Application Reference: 2019/2587/NMA

Proposed development at: Stanborough School, Lemsford Lane Welwyn Garden City AL8 6YR

Proposal: Non-material amendment to planning permission ref: 6/2019/2587/VAR

building + drawing title
**Proposed Music & Drama Block
 Landscape Plan**

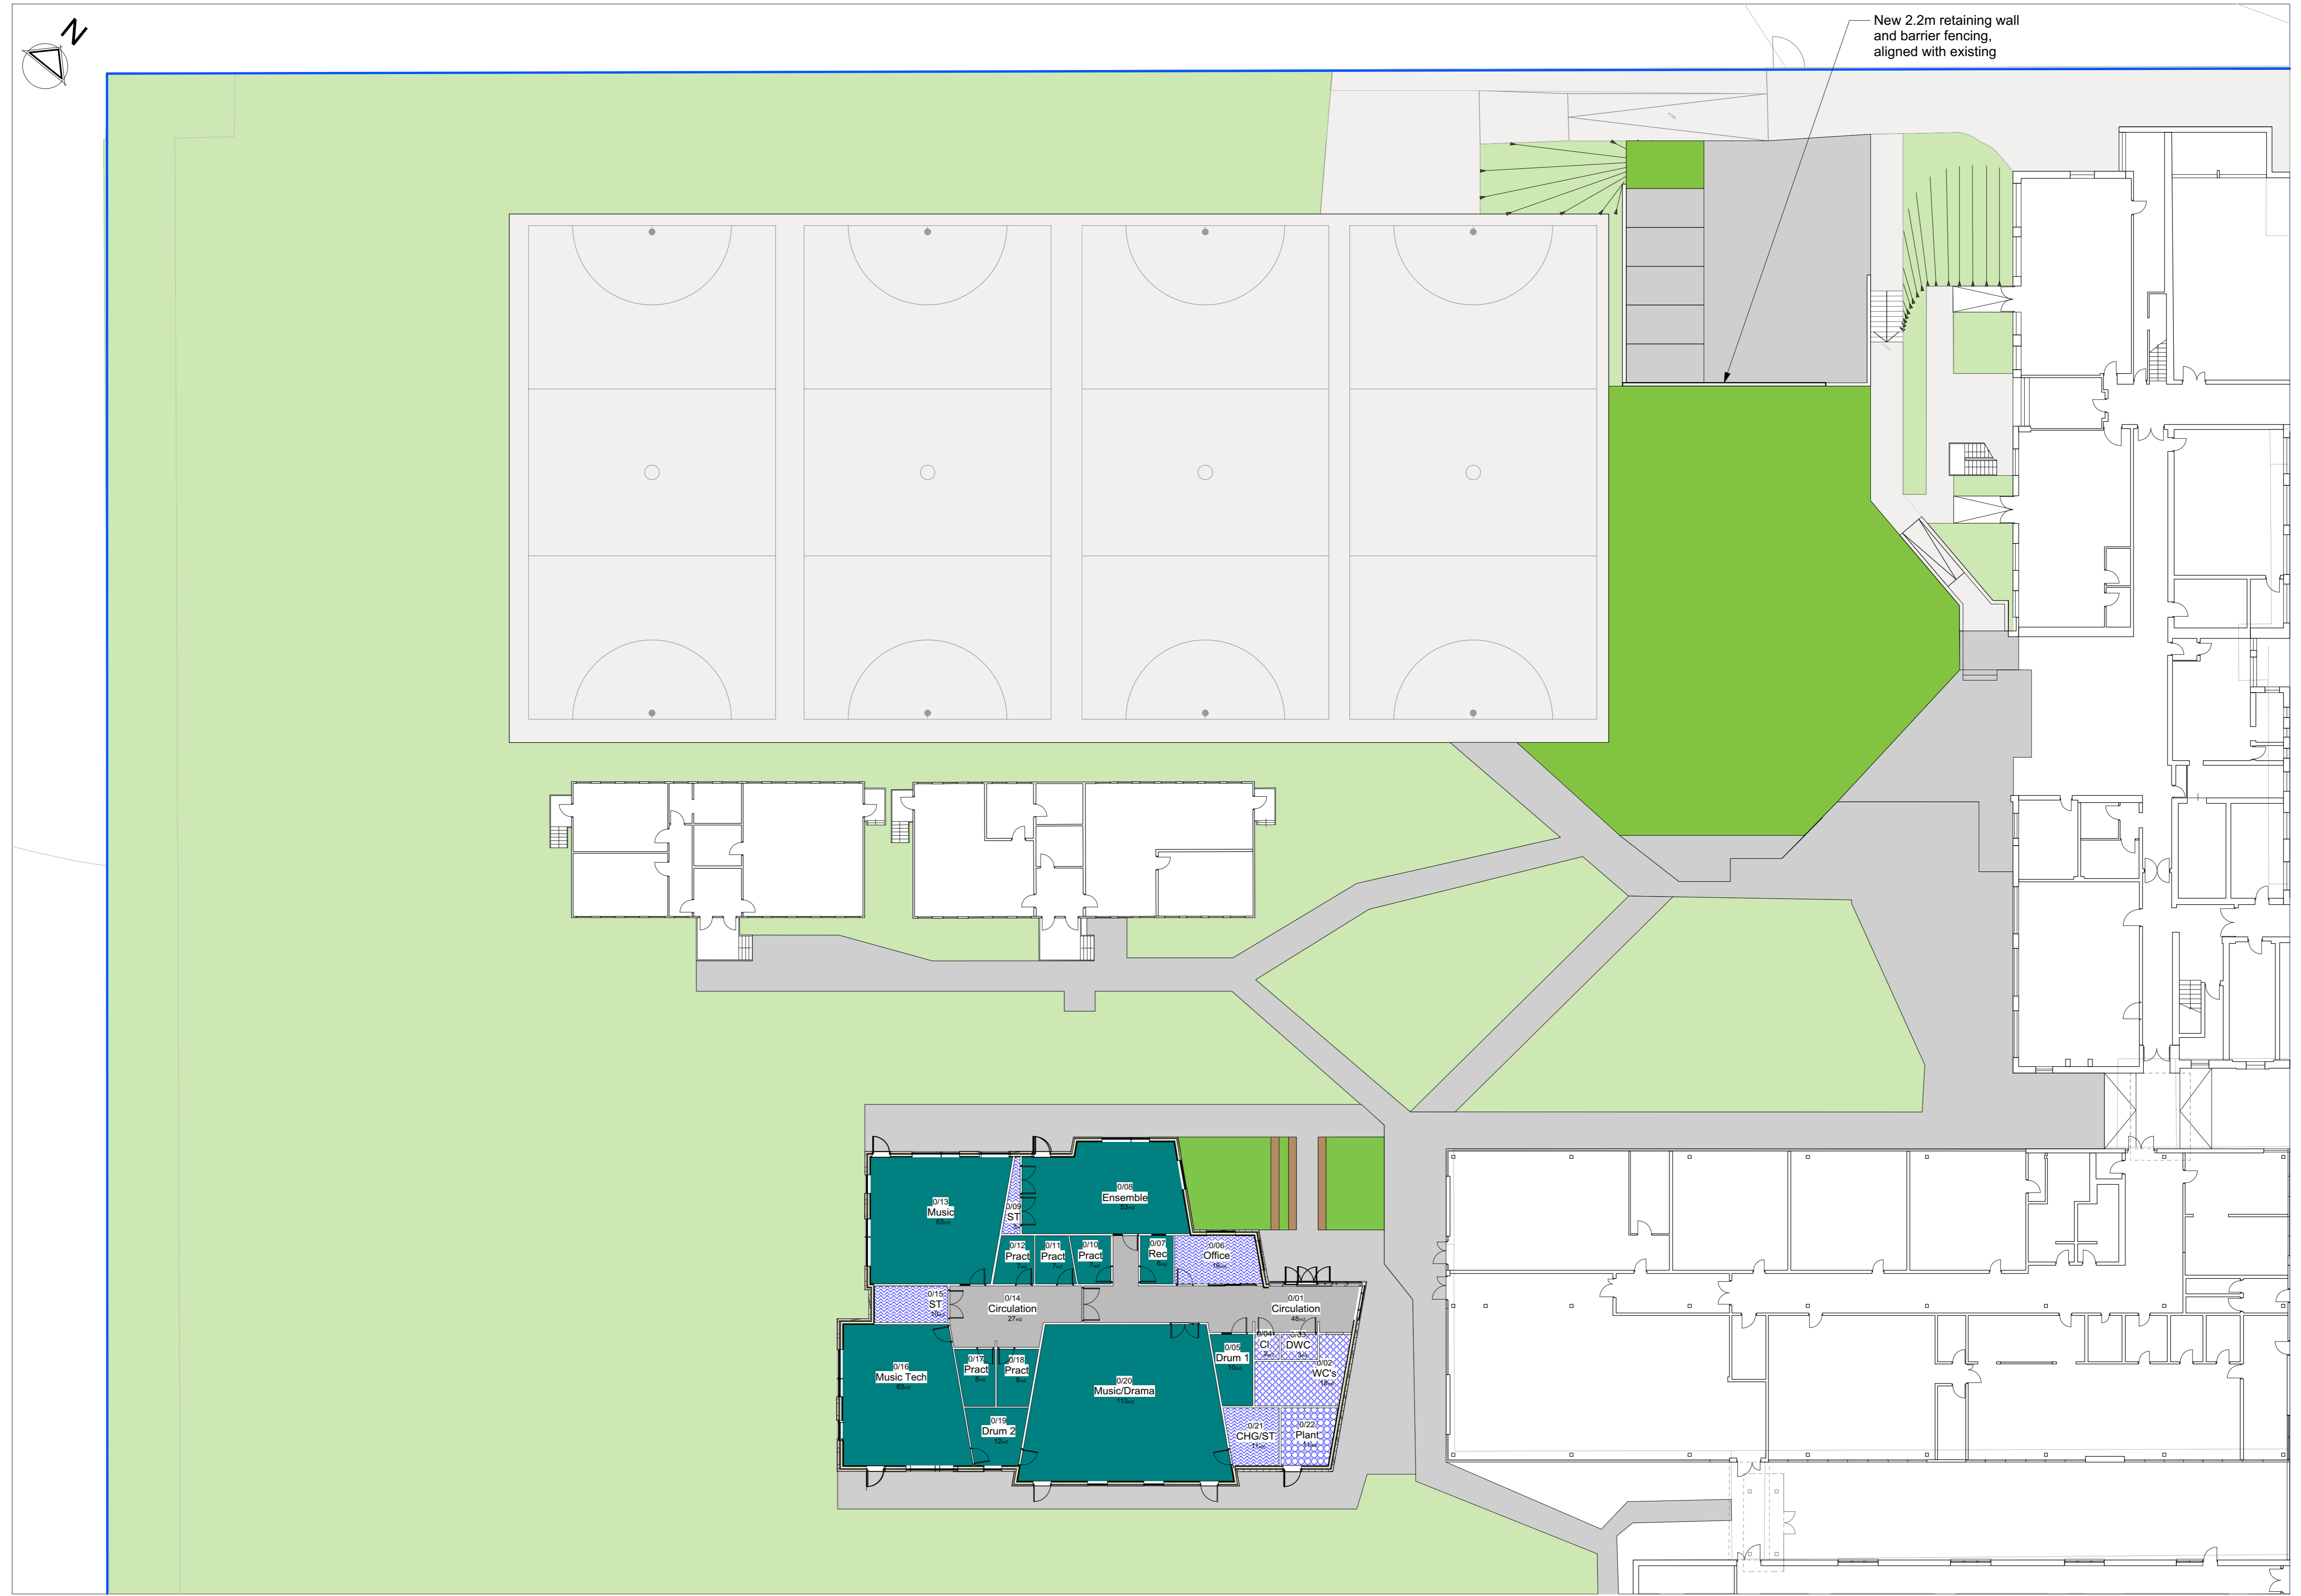
- A revised area of the demolished Music and Drama block which omits the retaining wall and which shows a grass embankment formed using retained spoil material. An area of tarmac will then be installed below this grass embankment.
- The loss of 5 car parking spaces.

The proposed amendments show the loss of 5 car parking spaces. The original planning application was assessed by Hertfordshire County Council as Highway Authority, who raised no objection to the proposals. This was on the basis of there being 5 car parking spaces in this exact location. To omit these spaces is a material consideration and one that which will require a new assessment as part of a planning application.

The amendments sought are material and you will require a new planning application for the changes shown. This application for a non-material amendment is therefore refused.
